SSD 7047 – Darling Harbour Integrated Display System – Response to Submissions

Government Submissions	Response
<i>Department of Planning and Environment</i>	
Third Party Advertising Further details are required for the proposed third party advertising, and in particular for 'partner info' and 'precinct partner' advertising including: ▪ mechanisms to control advertising content; and ▪ frequency and duration of third party advertising in comparison to other displays associated with signage including way finding and advertisement of events associated with the site.	In assessing this application, a certain level of planning ambiguity is caused by the requirement to define the intended use of the development through SEPP 64. In our view the Digital Content Management Plan (DCMP) (as updated) can help to address this ambiguity. Elements of the proposed development will be used for a range of uses, including: ▪ Precinct information; ▪ Wayfinding and public transit information; ▪ Promotion of public and cultural events; ▪ Health and safety information; ▪ Emergency communication; ▪ Public art; and ▪ Third party advertising Access to the proposed IDS will only be available to corporate part

P1,4

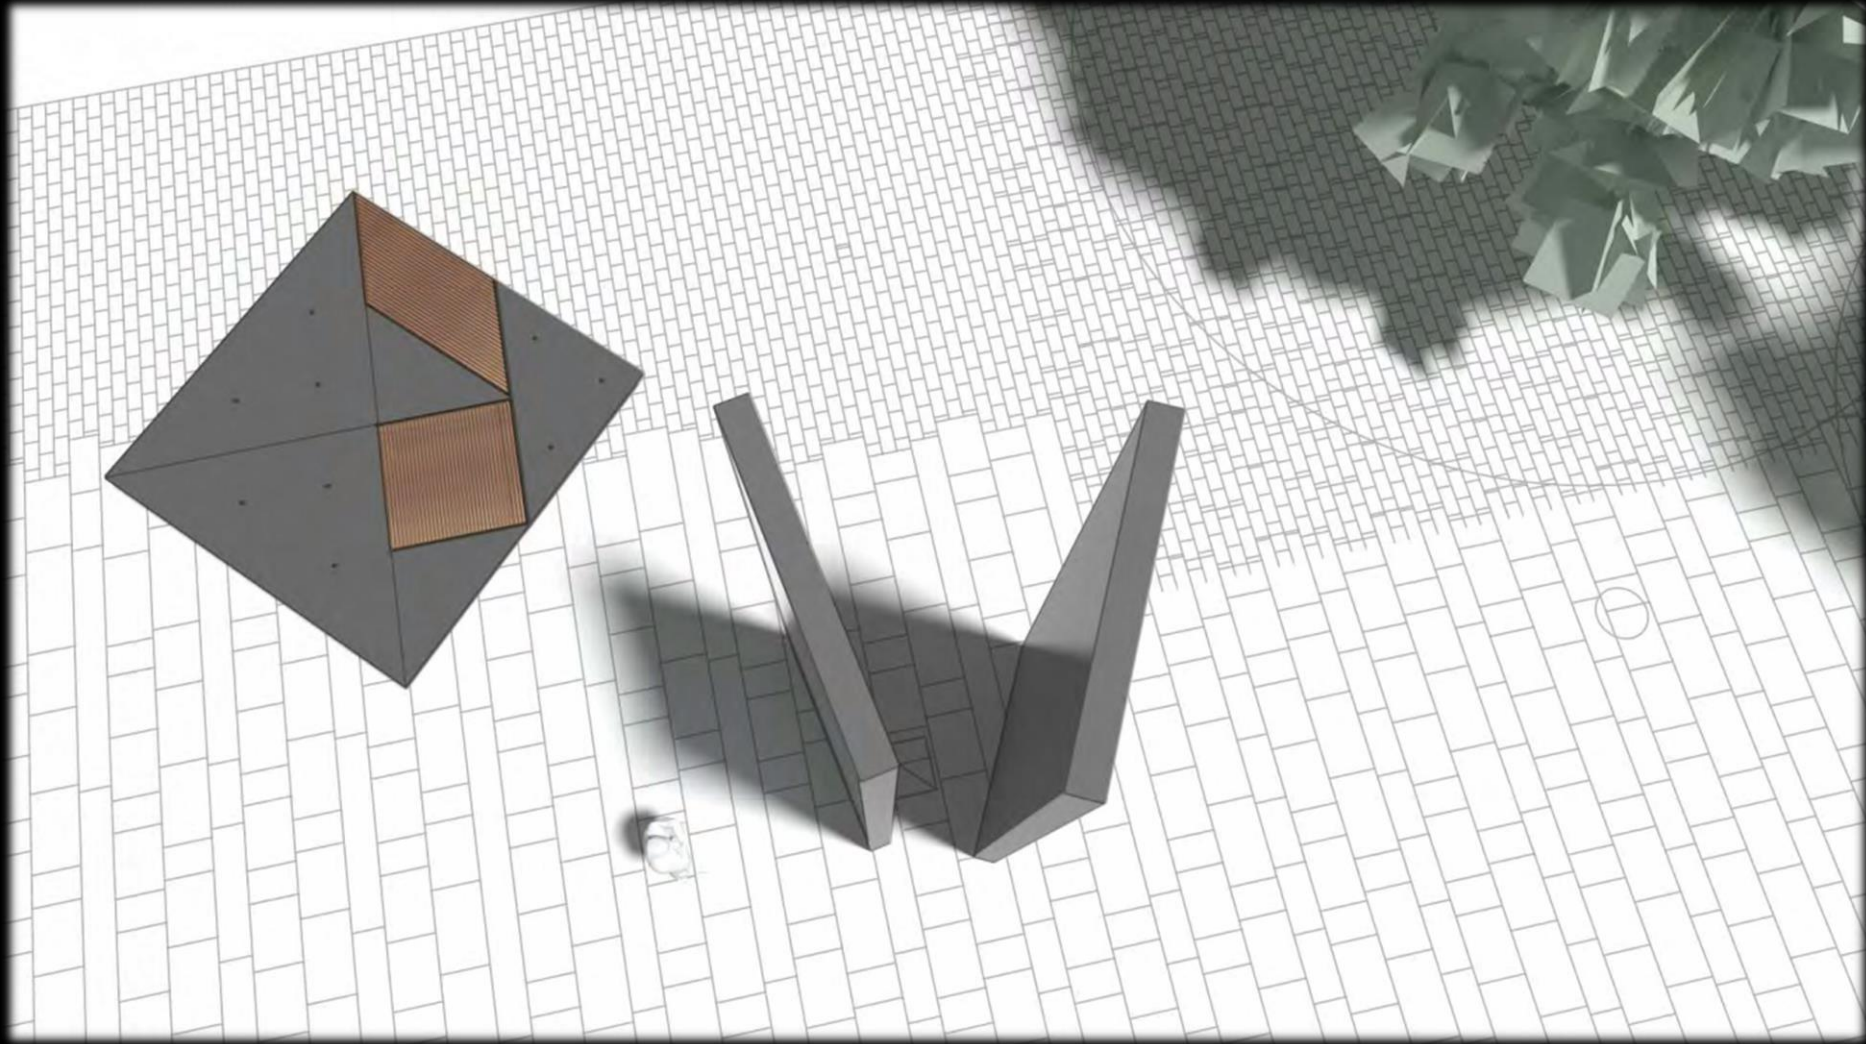
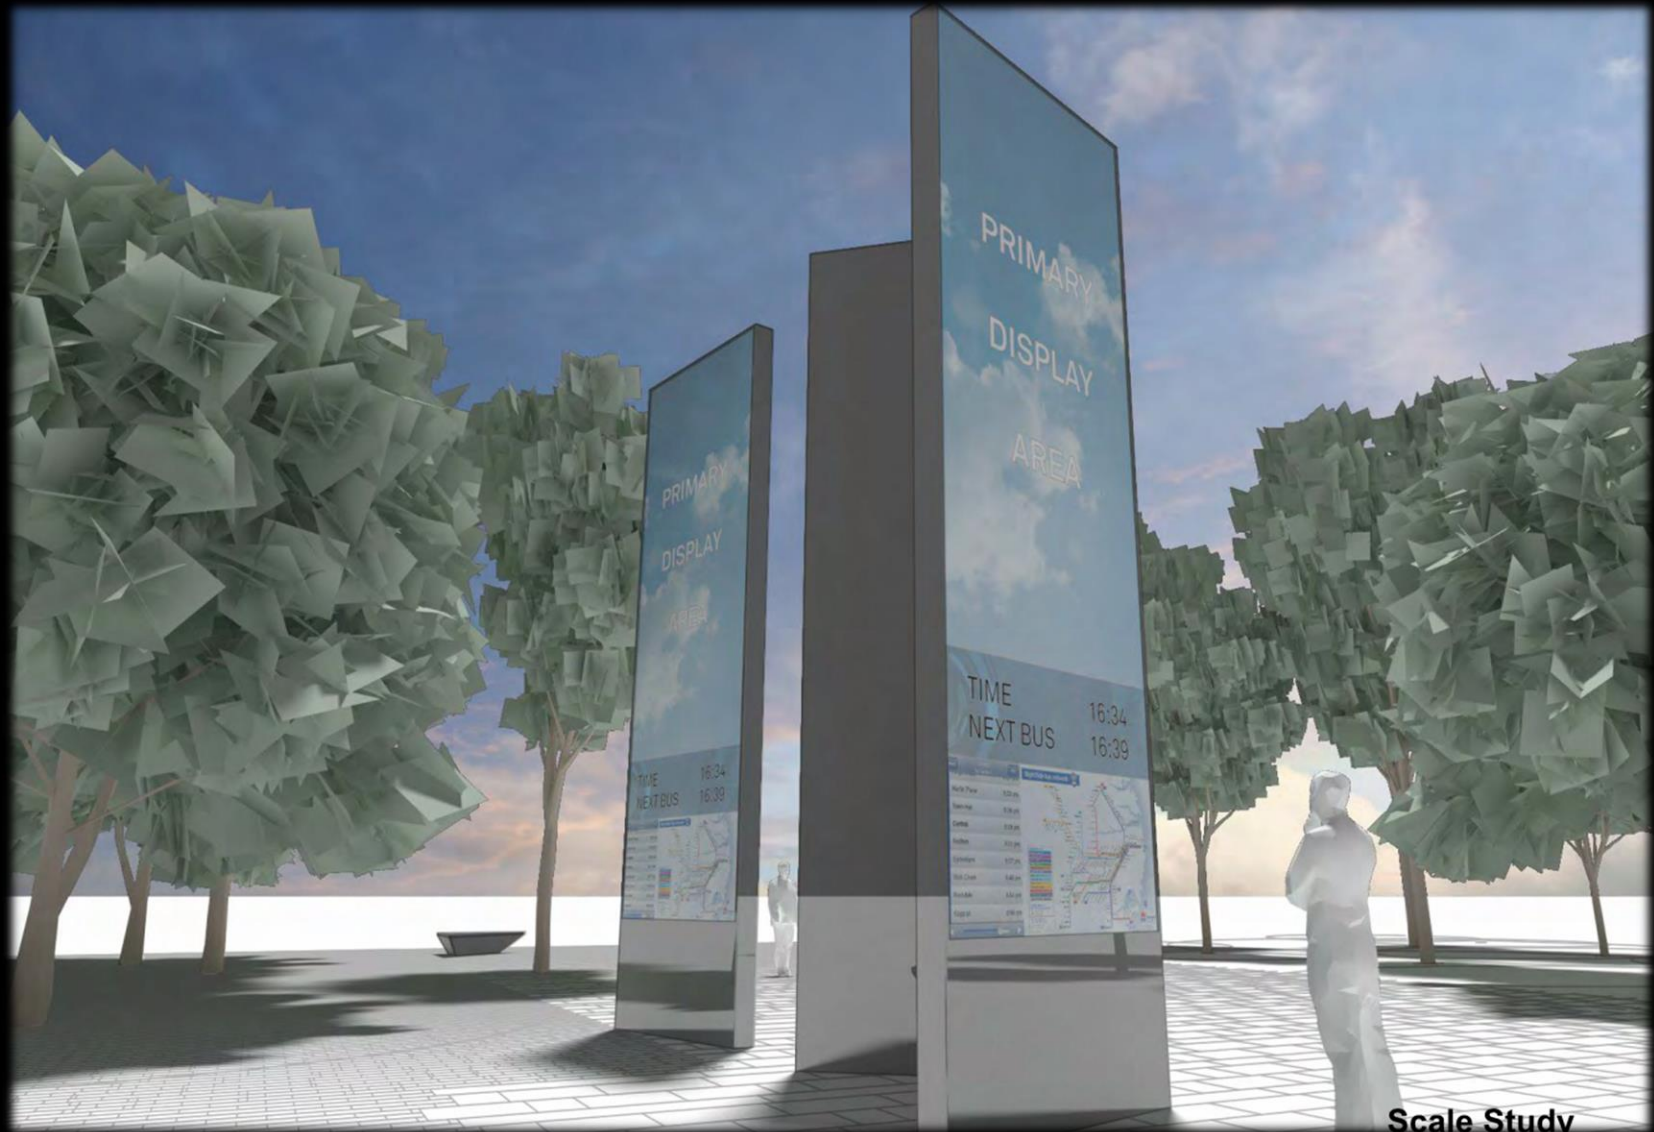
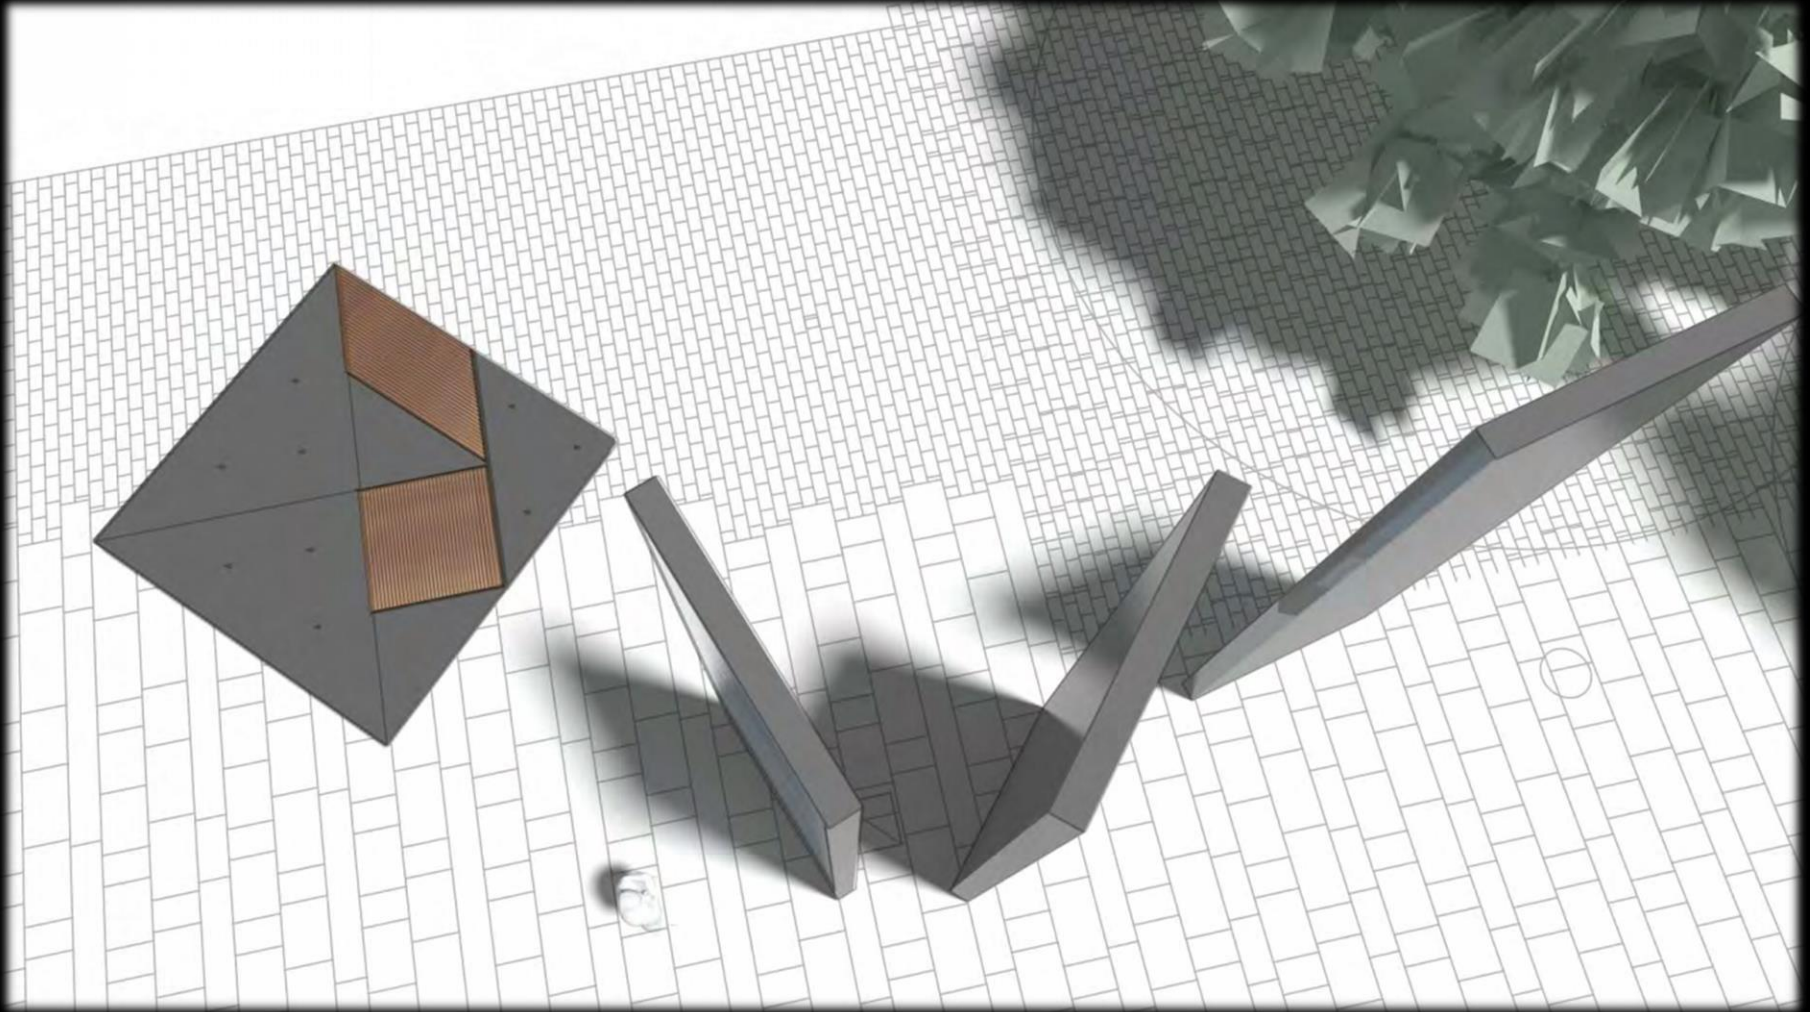
Dynamic LED Blade Signs (P01, P02, P03, P04, P05, P06) Clarification of the exact location of the dynamic LED blade signs is required, noting plans within the EIS are inconsistent.	Updated site plans are provided as Appendix G, these show the proposed locations of the public domain Blade Signs.
The frequency and size of the dynamic LED blade signs along the Boulevard have the potential to result in visual clutter, and potentially dominate and adversely impact on the future character of Darling Harbour at the Boulevard. Provide further consideration and options for: ▪ reducing the number of grouped blade signs, particularly proposed signs P4 and P6; ▪ reducing the height and scale of all blade signs to reflect a human scale; and ▪ locating blade signs to maintain a clear line of sight and walking path along the Boulevard.	The locations for the dynamic LED blade signs have been proposed following an exhaustive design process, which included discussions with the NSW Design Review Panel, which was chaired by the NSW Government Architect. The design has been iteratively developed to respond to the various requirements of the diverse future users of this public domain. Each one of the resulting blade signs is positioned to respond to the requirements of a specific audience. The final design for the location of the proposed Blade Signs has been rigorously assessed. As a result, the number of proposed blade signs is not proposed to be amended. The public domain in the ICC Sydney area is expected to be very busy with pedestrian traffic. The proposed Blade Signs are required to be larger than a human scale to ensure that they can be seen above the anticipated crowds. As the proposed Blade Signs signage will be used for communicating important precinct messaging during large public events maintaining the visibility of the signs at all times is important. Reducing the scale of the proposed signs would therefore result in an inappropriate outcome for this development and the precinct more broadly. The proposed blade signs are situated in locations that ensure a clear line of sight is maintained along the Boulevard. This line of sight can be seen within the updated photomontages provided as Appendix E.

Further details and justification is required for the 10m radius for audibility of the proposed blade signs including plans showing radius of audibility of signs at 2.5m, 5m and 10m.	The proposed blade signs will include the capability to project directional sound up to 10m in front of the unit. As the speakers associated with each blade sign are directional, the acoustic impact of each Blade sign will not be significant when perceived from the side or rear of any one sign. Due to the scale and height of the proposed signs, the optimal viewing distance for each screen is between 5m and 15m away. An acoustic range of 10m is therefore considered to be appropriate to allow for an overlap of the optimal viewing area and the audible

Public Domain "Blade" LED Screens The public domain "Blade" LED screens are proposed to be erected along the centre of the Pedestrian Boulevard in groups of two or more. These screens would attract visitors to congregate around these to seek information.	The Blade signs are proposed to be located at the edge of the main pedestrian transit area of the Boulevard. As demonstrated within the additional photomontages that have been prepared and are provided as Appendix E.

Government Submissions	Response
TfNSW advises that the screens should instead be erected along the edge of the Pedestrian Boulevard. This would ensure that no physical impediments are in the path of the heavy pedestrian traffic flow along the Pedestrian Boulevard, especially during events which are planned for the area.	
Road Safety Audit Some of the signs are located in close proximity to public roads and visible from the public roads. These signs may increase the likelihood of crashes on public roads. TfNSW requests that the applicant be conditioned to undertake the Road Safety Audits during the following stages for the proposed signage scheme, in accordance with <i>Austroads Guide to Road Safety Part 6: Road Safety Audit</i> by an independent TfNSW accredited road safety auditor: • Detailed Design; and • Operation. Based on the results of the road safety audit, the applicant shall review the design and implement safety measures as required.	As noted in the ARRB report as exhibited: <i>The principles of the Austroads road safety auditing guide have been applied to this assessment, and the knowledge and experience of the accredited audit team has been used to prepare this report.</i>

Public Realm Signs The City is very concerned given the cumulative advertising area of these signs is 152m². This will undoubtedly result in visual clutter in the precinct and will compromise the amenity and attractiveness of the public space. The signs also face onto a mixed use residential area, yet are proposed to be illuminated 24 hours per day. In light of this, and all of the above, these signs are not supported as currently proposed and it is recommended that they are deleted from the plans.	The States Design Review Panel has been involved in the Concept Design and Design Development of the Interactive Display System. The process for review included a number of Design Review Panel Presentations where the design evolved significantly, and in particular included the development of the agreed design of the Boulevard Blade Structures and the removal of a number of façade signs (previously named C08 and E01). These comments were made to ensure that the developed design delivered on the key principals of the endorsed precinct masterplan. Signoff by the DRP of the finalised solution occurred on the 4th December 2015 The locations for the dynamic LED blade signs have been proposed following an exhaustive design process, which included discussions with the NSW Design Review Panel, which was chaired by the NSW Government Architect. The design has been iteratively developed to respond to the various requirements of the diverse future users of this public domain. Each one of the resulting blade signs is positioned to respond to the requirements of a specific audience. The final design for the location of the proposed Blade Signs has been rigorously assessed. As a result, the number of proposed blade signs is not proposed to be amended. The public domain in the ICC Sydney area is expected to be very busy with pedestrian traffic. The proposed Blade Signs are required to be larger than a human scale to ensure that they can be seen above the anticipated crowds. As the proposed Blade Signs signage will be used for communicating important precinct messaging during large public events maintaining the visibility of the

Government Submissions	Response
	signs at all times is important. Reducing the scale of the proposed signs would therefore result in an inappropriate outcome for this development and broader precinct. The proposed blade signs are situated in locations that ensure a clear line of sight is maintained along the Boulevard. This line of sight can be seen within the updated photomontages provided as Appendix E. An assessment of the illuminance impact of the proposed blade signs was completed as part of the EIS (refer to Appendix E of the EIS). That assessment noted that the illuminance impact of the blade signs would be 0.18 lux at 100m and would reduce to 0.01 lux at 500m. Although the cumulative area of the blade signs is noted by the City, the location of the blade signs avoids any cumulative impact being experienced by the mixed use residential area from the combined display area of the blade signs. Further consideration of the design of the proposed blade signs is found in Section 3.3. of the Design Report provided as Appendix B within the exhibited EIS.
